**LORETO NORMANHURST SCHOOL REDEVELOPMENT (CONCEPT PROPOSAL & STAGE 1) Application
No SSD-8996**

RESIDENT SUBMISSION: I object to three aspects of the project as detailed on the following two pages on the basis of 1) TRAFFIC, 2) SIZE OF BOARDING HOUSE, 3) INCREASE IN STUDENT NUMBERS.

2 SITE ELEVATION - MOUNT PLEASANT AVENUE
1:500

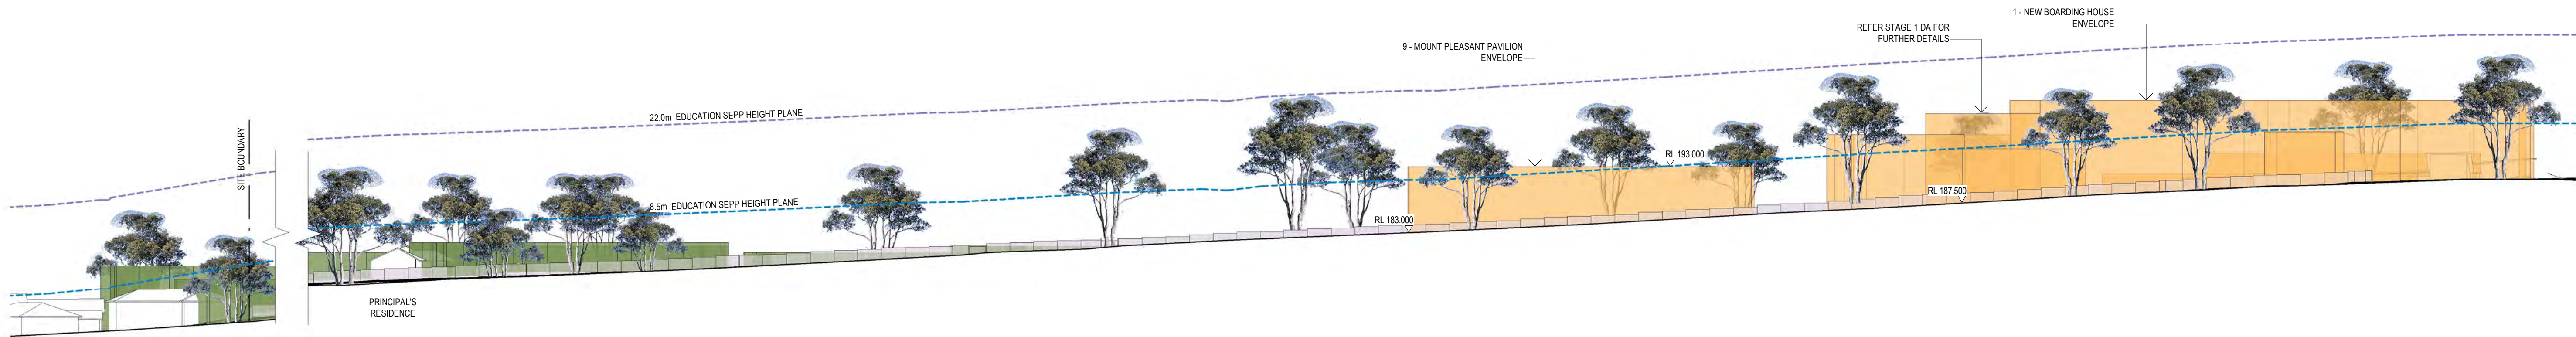
I object to the size and height of the proposed 7 level boarding house which includes 2 basement levels. Even with excavation, the AJC architectural elevations (ELEVATIONS SHEET 1 DA31013) show at least 4 levels above Mt Pleasant Avenue ground level, plus extra height on the roof due to services etc. The south west elevation, visible from Mt Pleasant Avenue, shows 6 levels above ground level of the site. This height and bulk of building is out of keeping with the surrounding residential area comprising one and two storey family homes.

In earlier meetings with residents, the College foresaw a three storey building partially below ground. To be in keeping with the surroundings and residential zoning, I believe the building should not exceed two storeys above ground level to reduce its dominating visual impact on Mt Pleasant Avenue.
